DRB CASE ACTION LOG (PREL & FINAL)

DRB Application No.: <u>04DRB-00938 (P& F)</u>	Project # <u>1002224</u>
Project Name: <u>LOS POBLANOS RANCH</u>	
Agent: <u>Isaacson & Arfman PA</u>	Phone No.: <u>268-8828</u>

**CITY OF ALBUQUERQUE
PLANNING DEPARTMENT
DRB COMMENTS
OCTOBER 13, 2004**

RE: Tract A, Los Poblanos Ranch /preliminary & final plat

**PLAT
FOR
TRACT A
LOS POBLANOS RANCH**

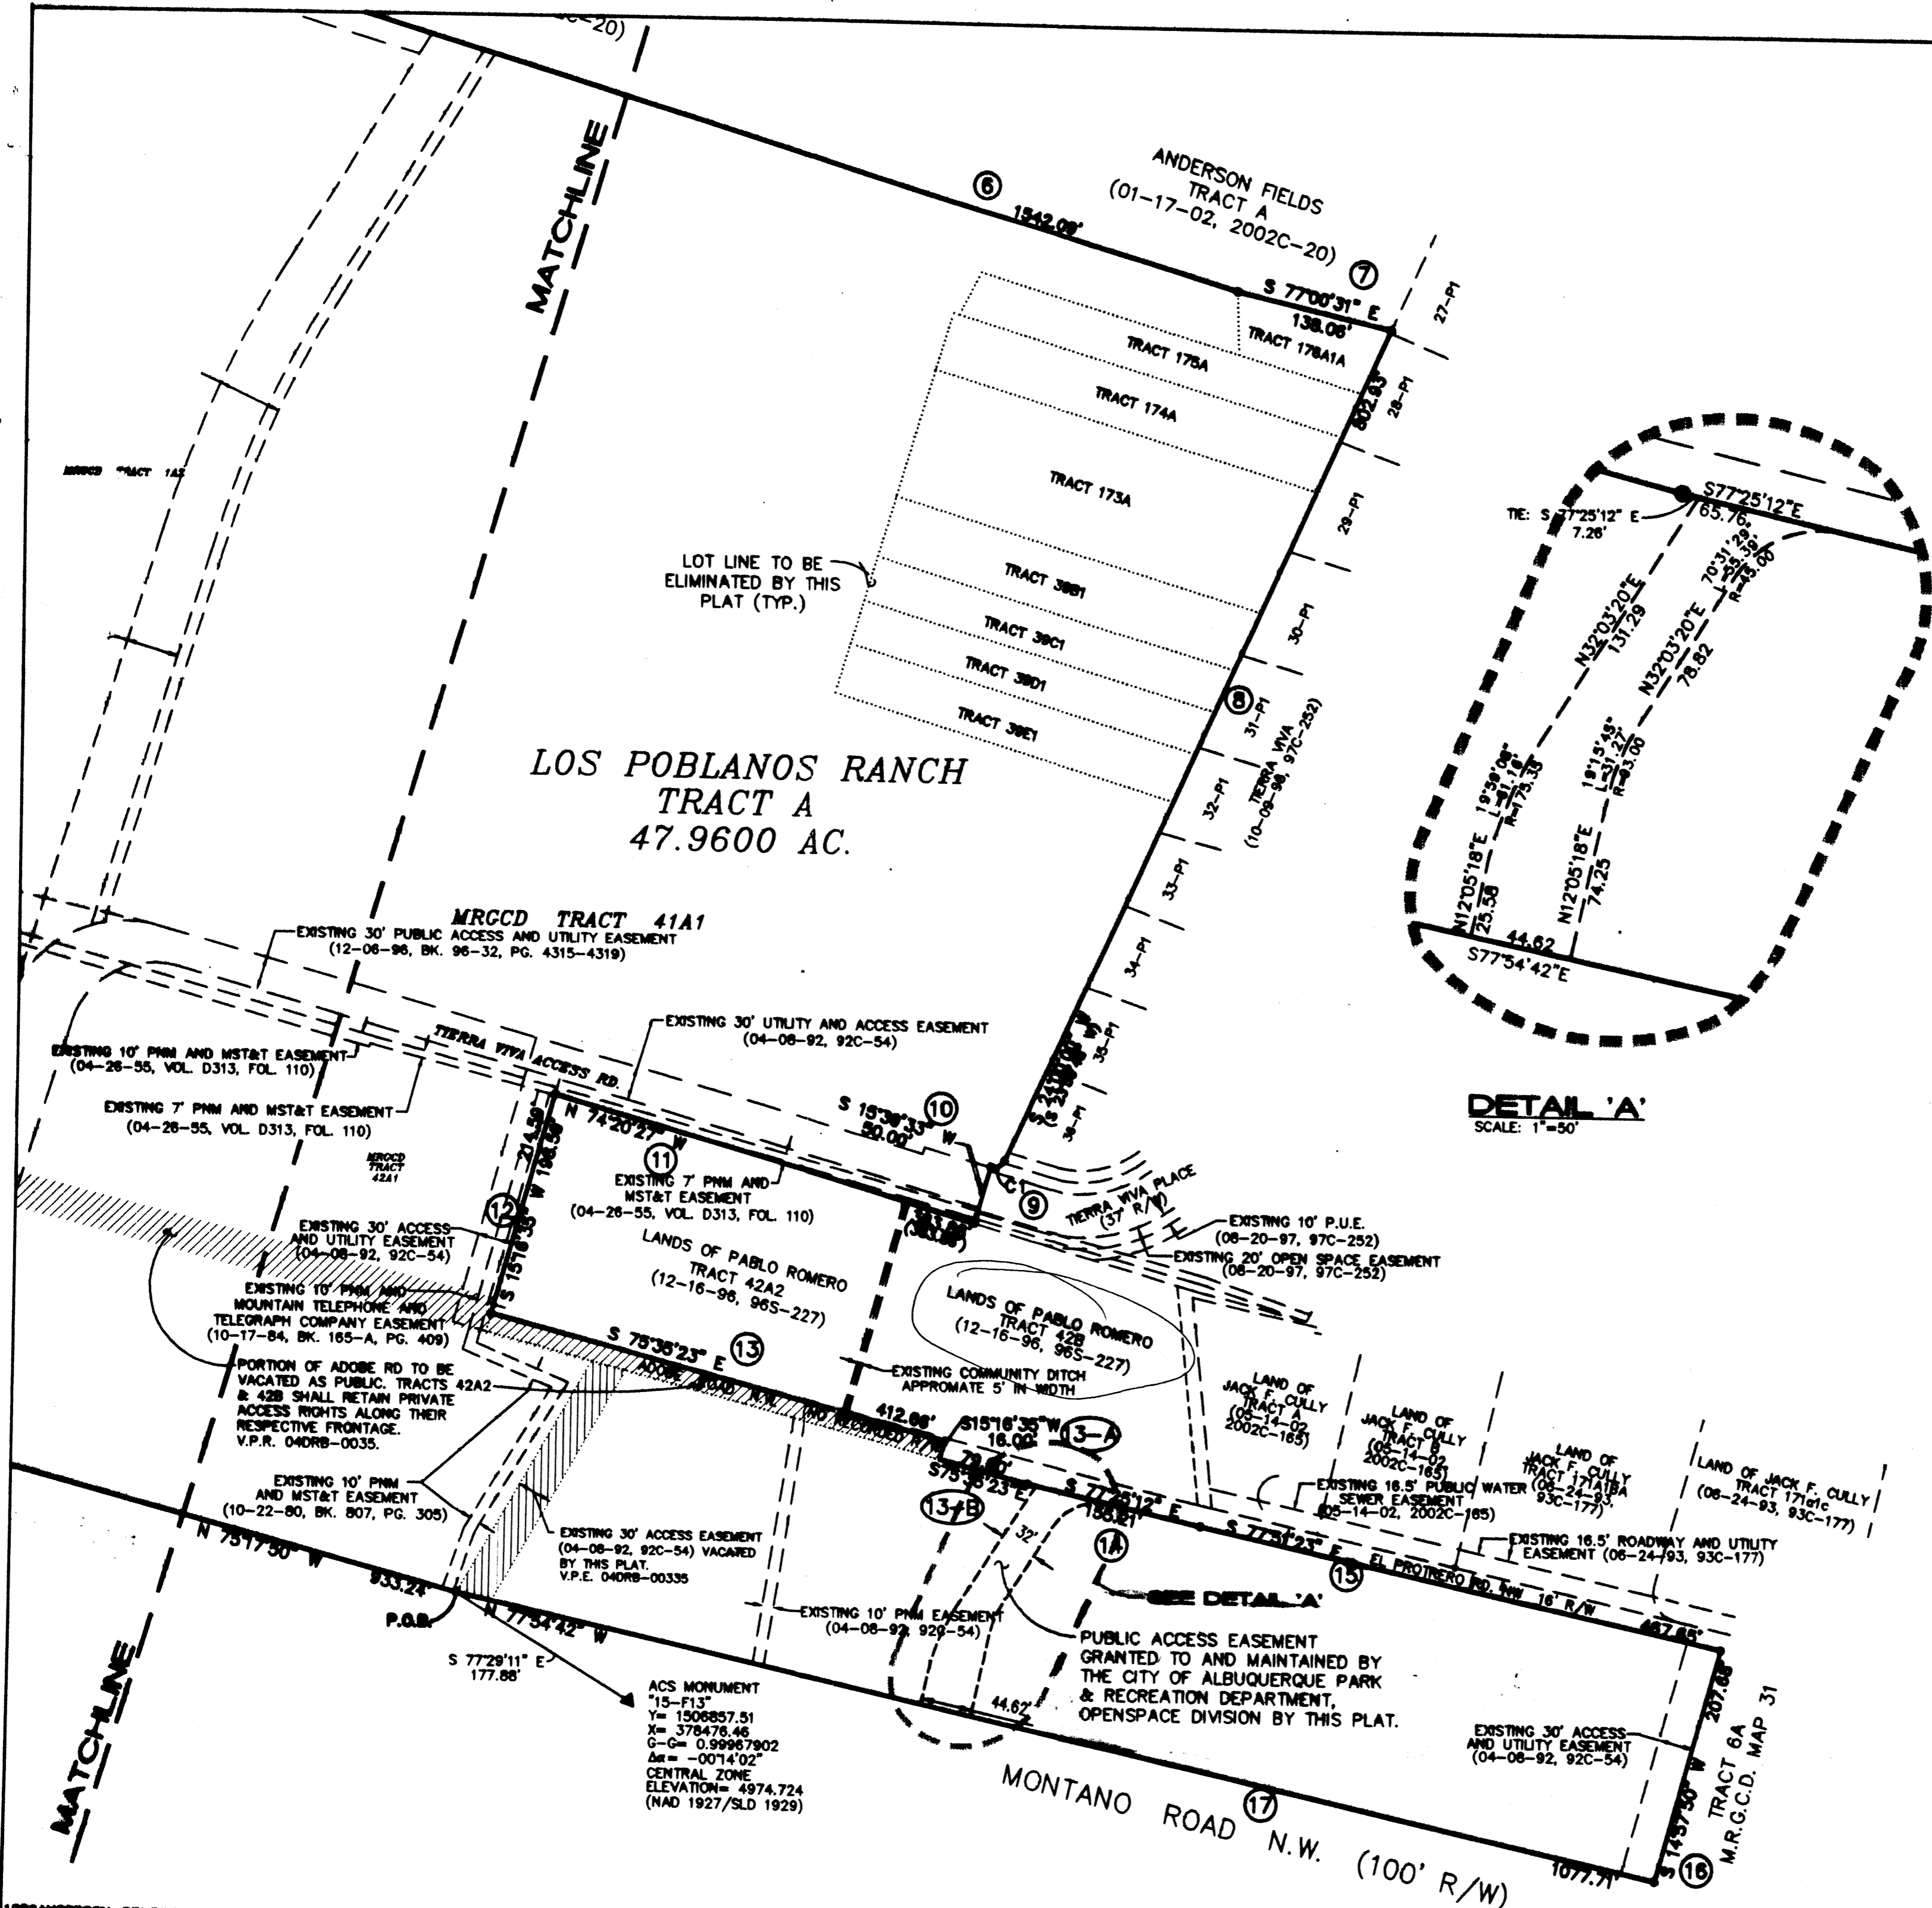
UTILITIES: ① Add 20' wide public water line easement for existing waterline between Ald Adobe Road and Mantano.

② Add / retain public water/sewer easements to SE corner of Tract 42A2

The plat language showing which lines are vacated by the platting action should say "lines" instead of "line" for clarity.

Subdivision Ordinance requires the current zoning appear on the plat under Subdivision Data.
